Bramford to Twinstead Reinforcement

Document 8.9.4: Applicant's Comments on Other Submissions Received at Deadline 6

Final Issue A
January 2024

Planning Inspectorate Reference: EN020002

STOUR VALLEY EAST  
 CABLE SEALING END  
 COMPOUND AT LITTLE  
 CORNARD

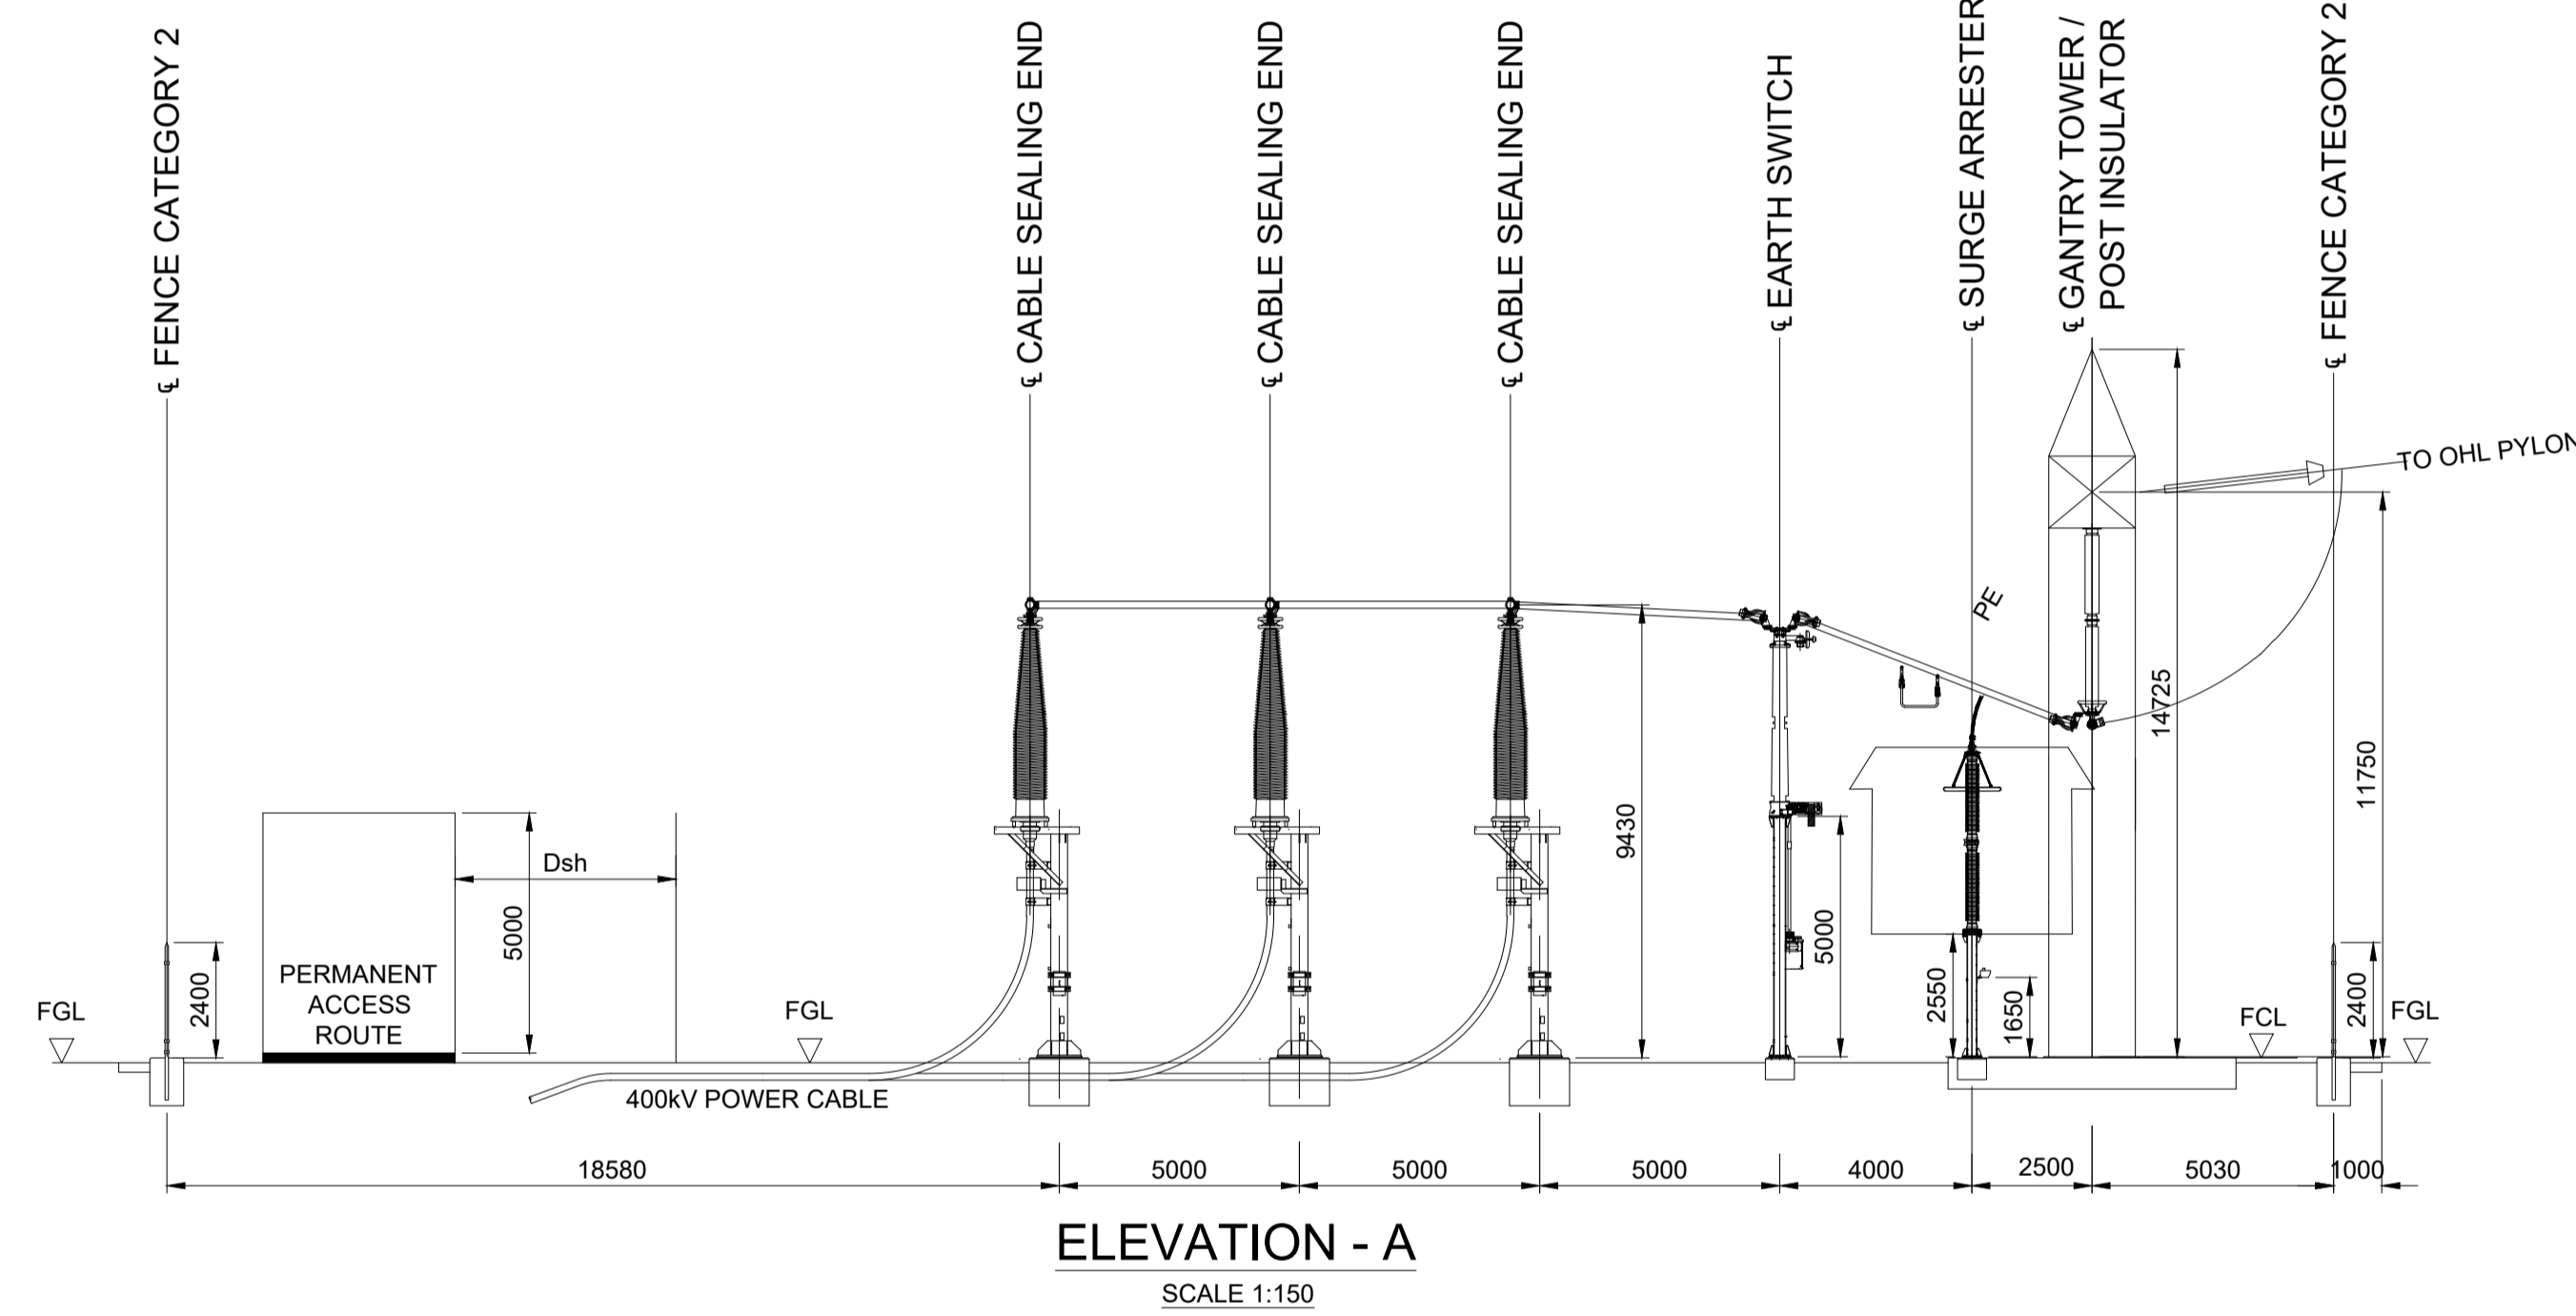
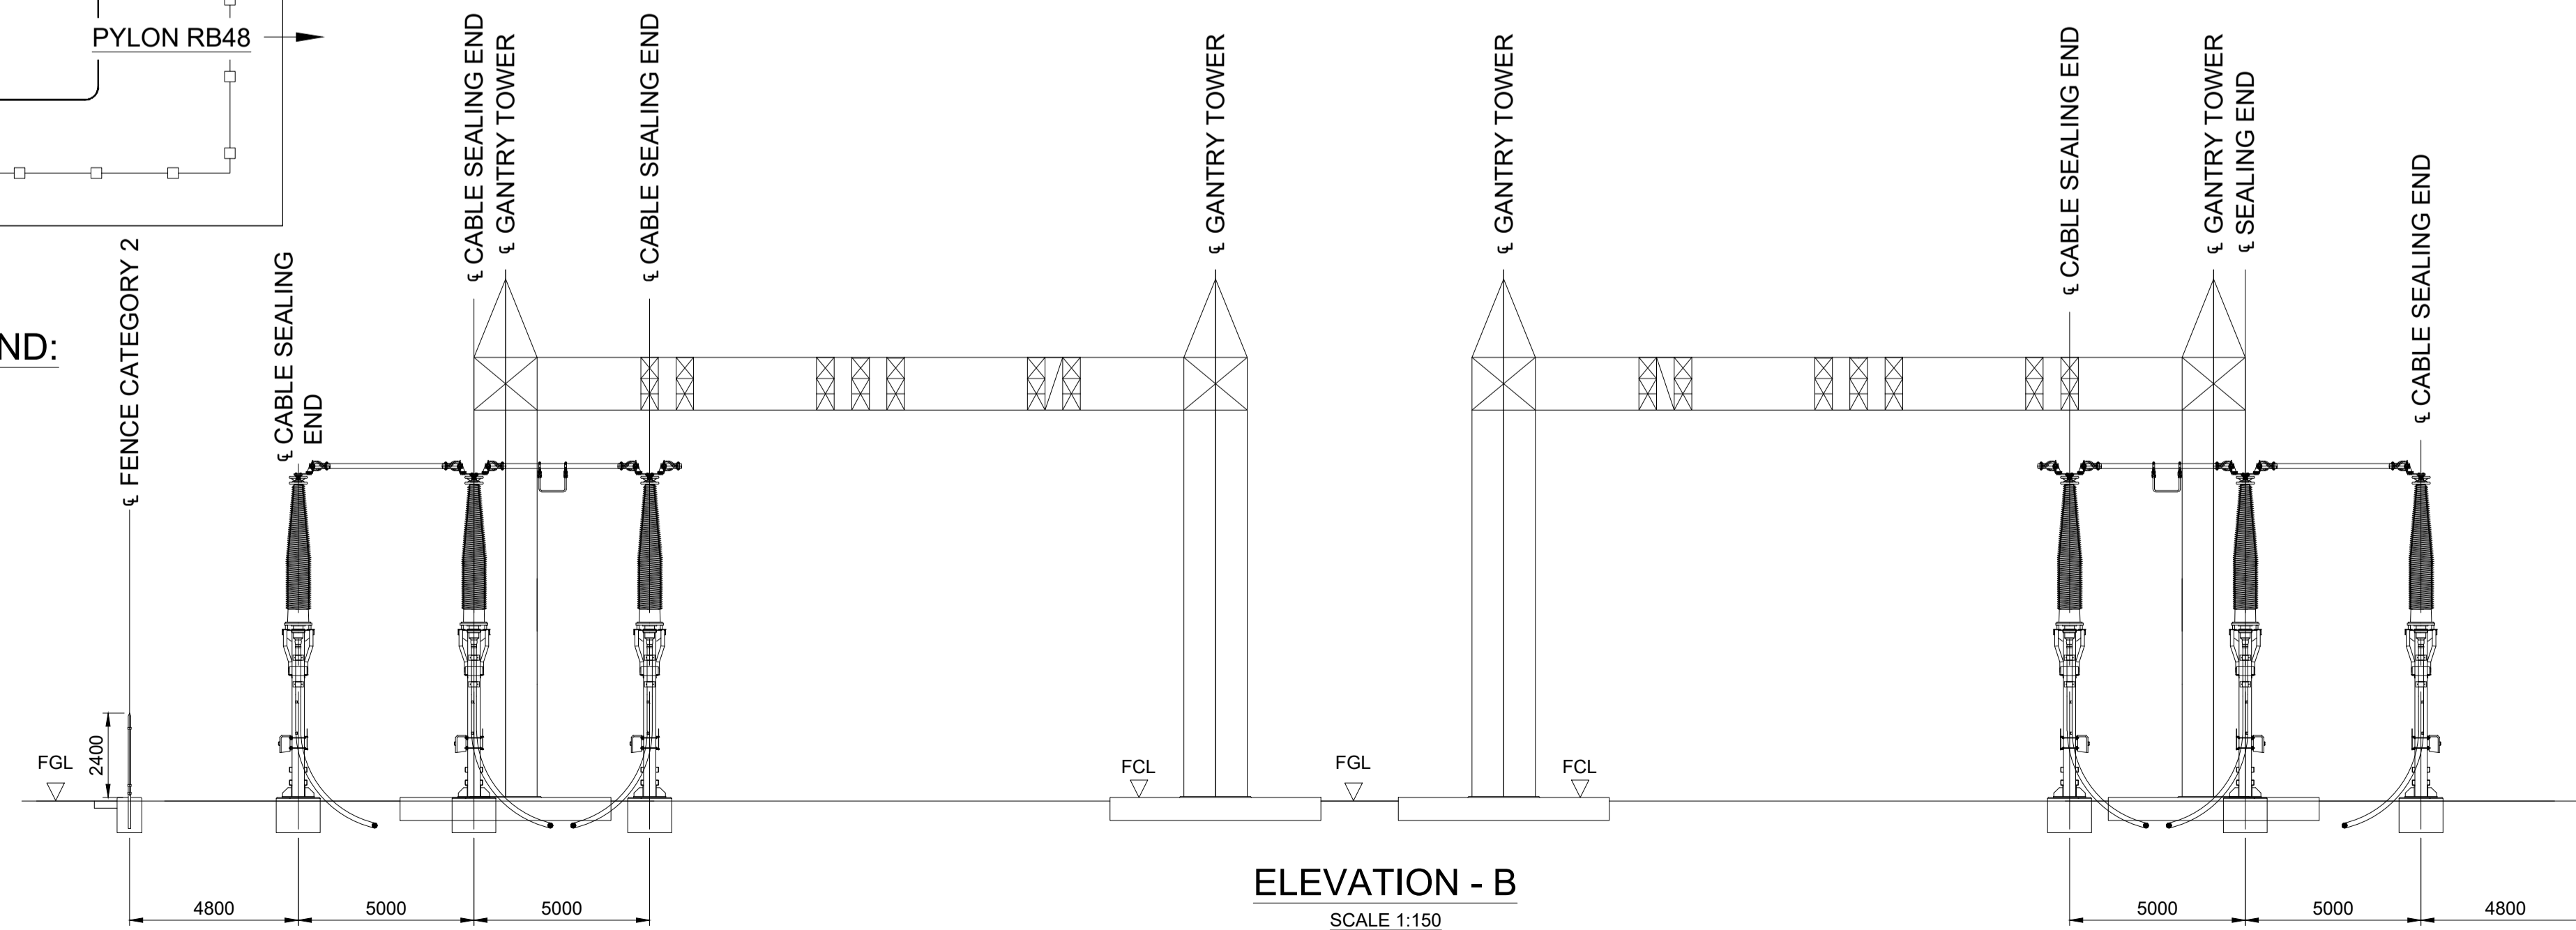
- 2.3.3 Babergh and Mid Suffolk District Councils notes that they still have concerns and comments in respect to the Dedham Vale East cable sealing end (CSE) compound and Stour Valley East CSE compound. The Applicant responded to specific points on these in the Applicant's Comments on Other Submissions Received at Deadline 5 [REP6-045] in Section 2.4 and Table 7.1 respectively.

The Applicant updated Requirement 9 of the draft DCO [REP6-003] at Deadline 6 to confirm that the reinstatement planting plan submitted to the relevant planning authority must include a landscape plan for each CSE compound, which will show the proposed hard and soft landscaping and proposed finishes for hard landscape features in response to the Councils on this matter.
